**Re: Kiddie Academy Westside**  
**Project Address (need an address)**  
**Traffic Circulation Layout**  
Architect's Stamp 03-31-2020 (C12-D003A)

Based upon the information provided in your submittal received 06-12-2020, the above referenced plan cannot be approved for Building Permit until the following comments are addressed:

A1 CLEAR SIGHT DISTANCE PLAN

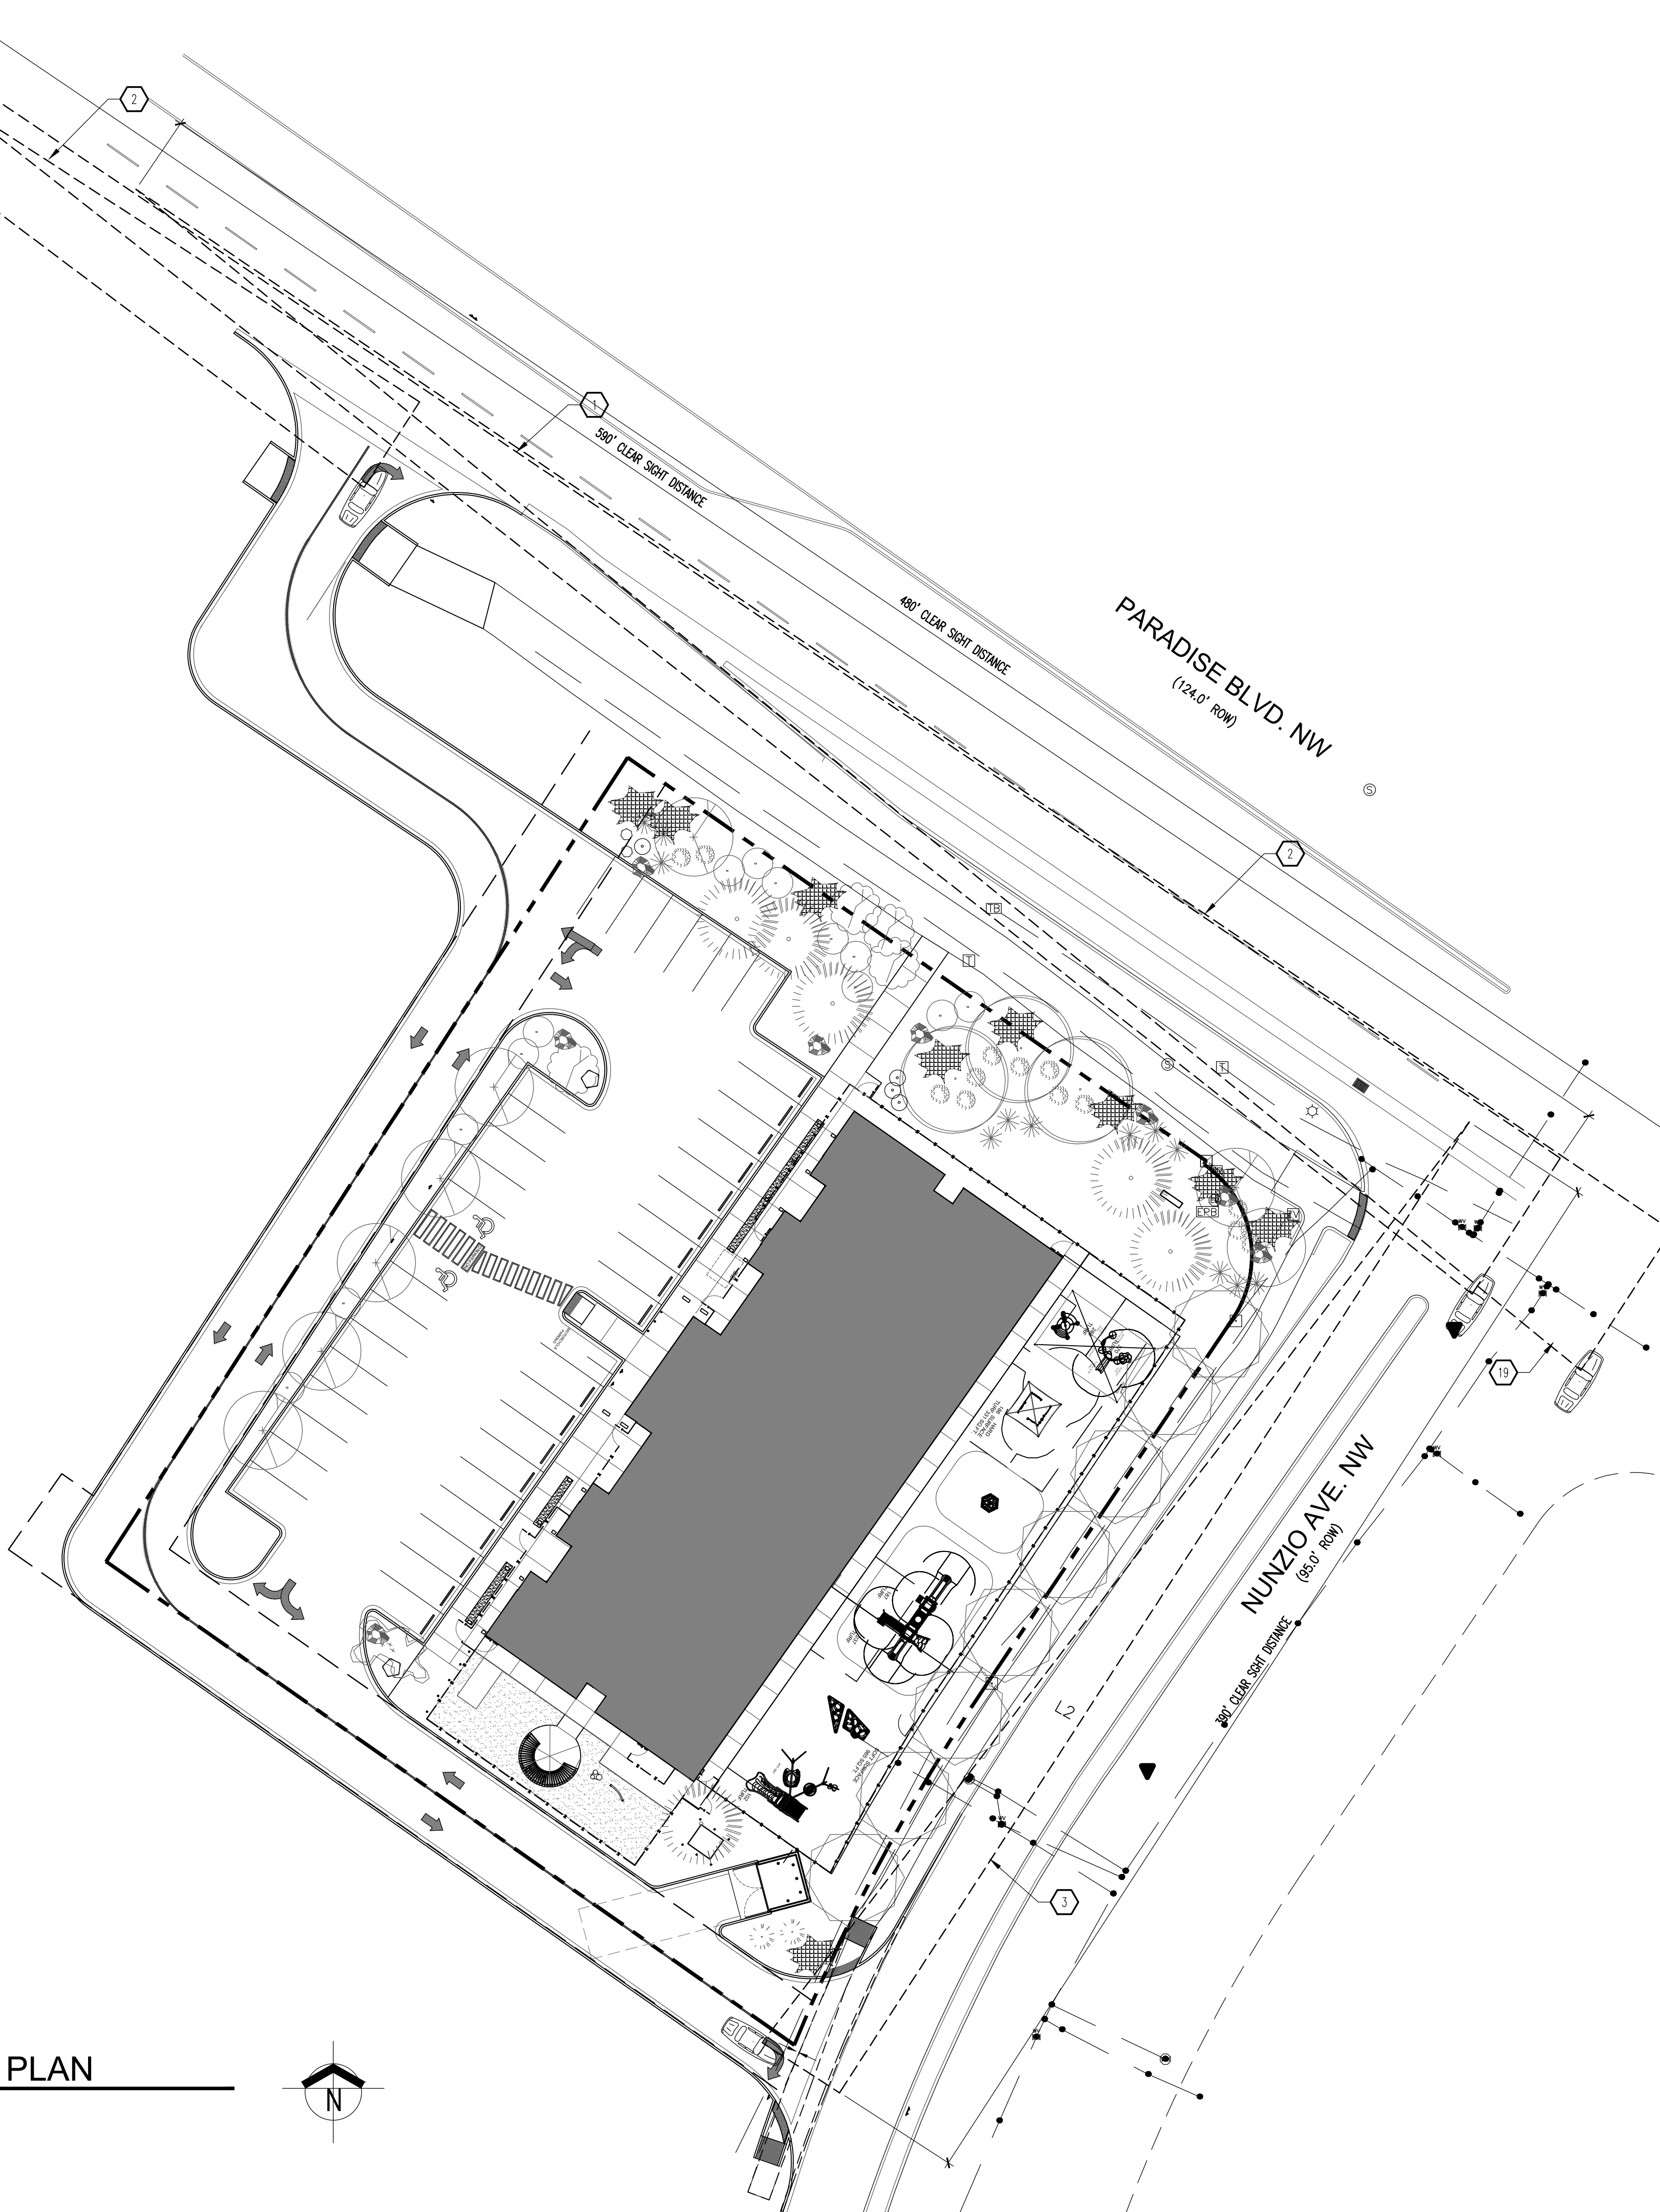
13. Please provide a sight line distance exhibit for the intersection of Paradise and Nunzio with proposed landscaping (see attachment for exhibit). Provide sight line on Nunzio left and right turn movements with the proposed landscaping. **This has not been addressed from prior comments.**

14. Show the clear sight triangle and add the following note to the plan( this note has been added from prior comments): "Landscaping and signage will not interfere with clear sight requirements. Therefore, signs, walls, trees, and shrubbery between 3 and 8 feet tall (as measured from the gutter pan) will not
